KIRKLEES METROPOLITAN COUNCIL INVESTMENT & REGENERATION SERVICE

Reference No:	2026/62/91924/E
Site Address:	16, Syke Ing Close, Earlsheaton, Dewsbury, WF12 8HF
Description:	Erection of front dormer extension
Recommending Officer:	Ellen Gilbert

DECISION – REFUSED

PROPOSED FRONT ELEVATION
South East

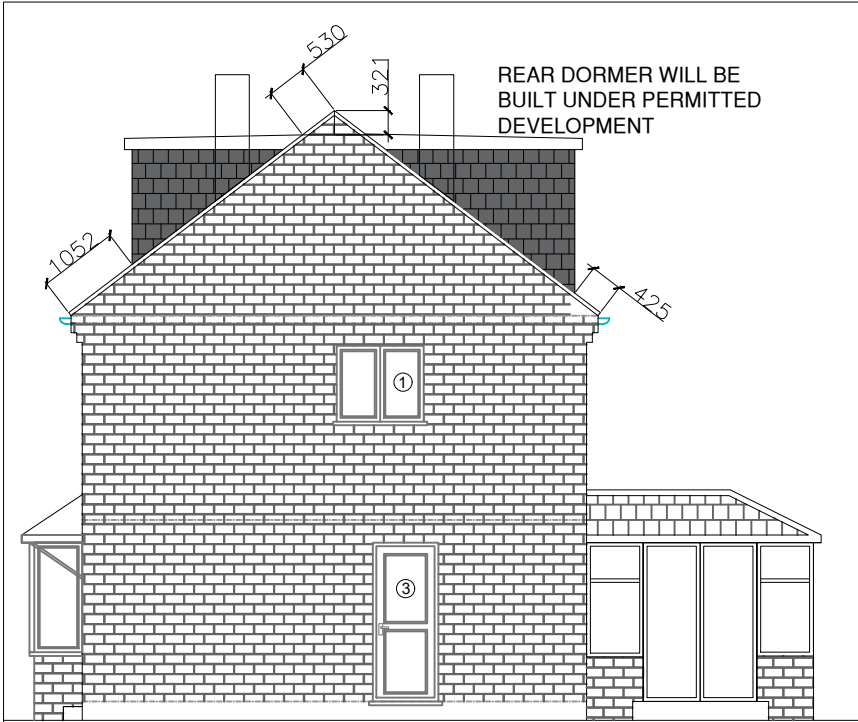
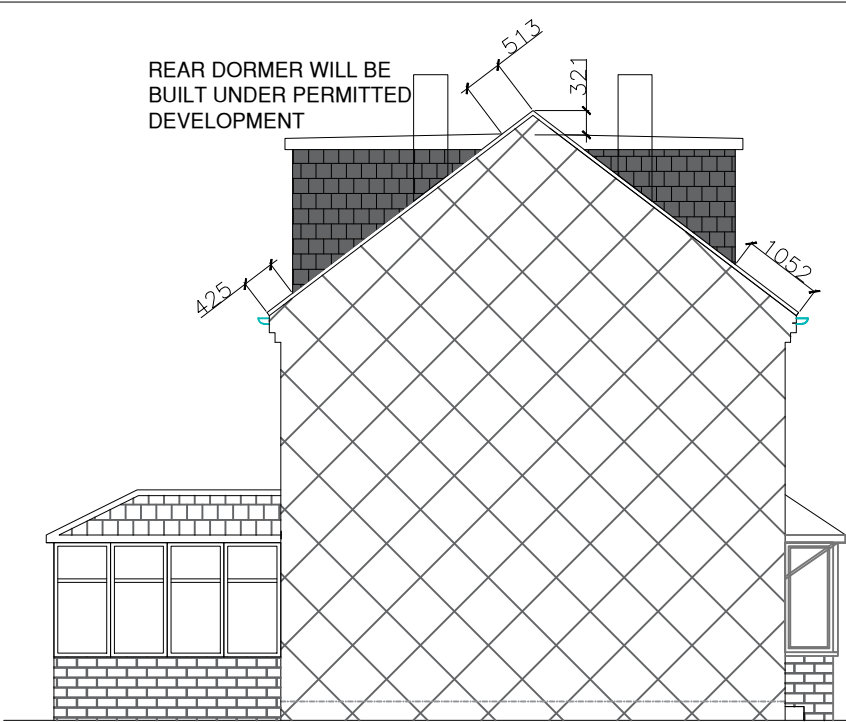
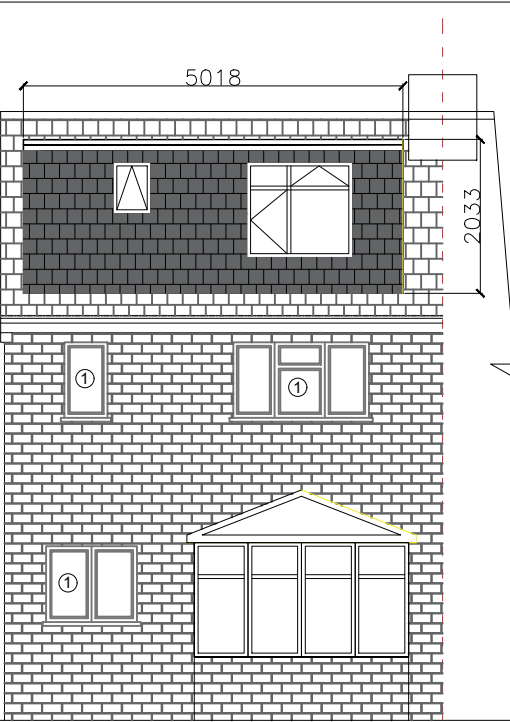
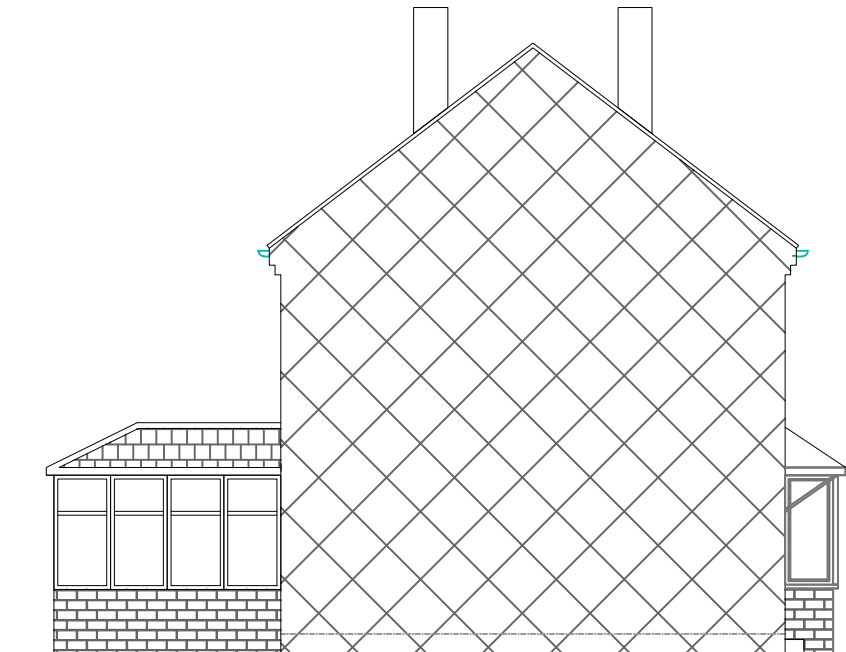
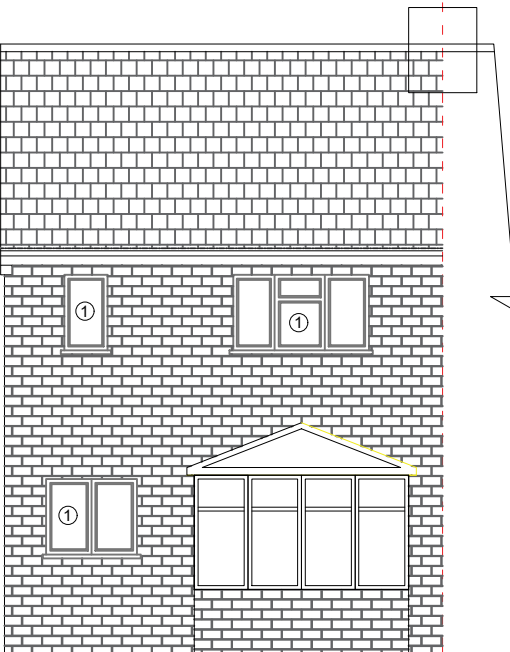
The proposed front dormer would introduce a prominent and incongruous addition to the principal roof slope. The host dwelling forms part of a group of similarly designed semi-detached properties characterised by simple, uncluttered roof forms. Consideration was given by the case officer to the surrounding roofscape, however in this instance, the proposed dormer would form the only visible roof extension in the vicinity and would therefore appear as a dominant feature rather than a subordinate addition. Significant weight is afforded to the appearance of the principal elevation, particularly given the dwelling’s prominent outlook across the adjacent public greenspace. Due to its scale, form and highly visible position, the proposed dormer would appear visually intrusive and incongruous within the street scene, causing harm to the character and appearance of both the host dwelling and the wider area.

proposed dormer would measure approximately 3 metres in width. As a result, the dormer would occupy a substantial proportion of the principal roof slope and would appear bulky. In addition, the proposed would be centrally positioned within the front roof slope and would interrupt the balanced appearance of the dwelling's principal facade. In this case, it can therefore be considered that the proposal would detract from the symmetry of the dwelling.

1. The proposed dormer extension, by reason of its scale, massing, height, siting and design would represent an overly dominant and visually intrusive addition that would disrupt the simple form and appearance of the existing roof. The proposed would appear incongruous within the streetscape, causing harm to the character and appearance of the dwelling and surrounding area. The proposal is therefore contrary to Policy LP24 of the Local Plan and policy DP3 of Chapter 14 of the National Planning Policy Framework.
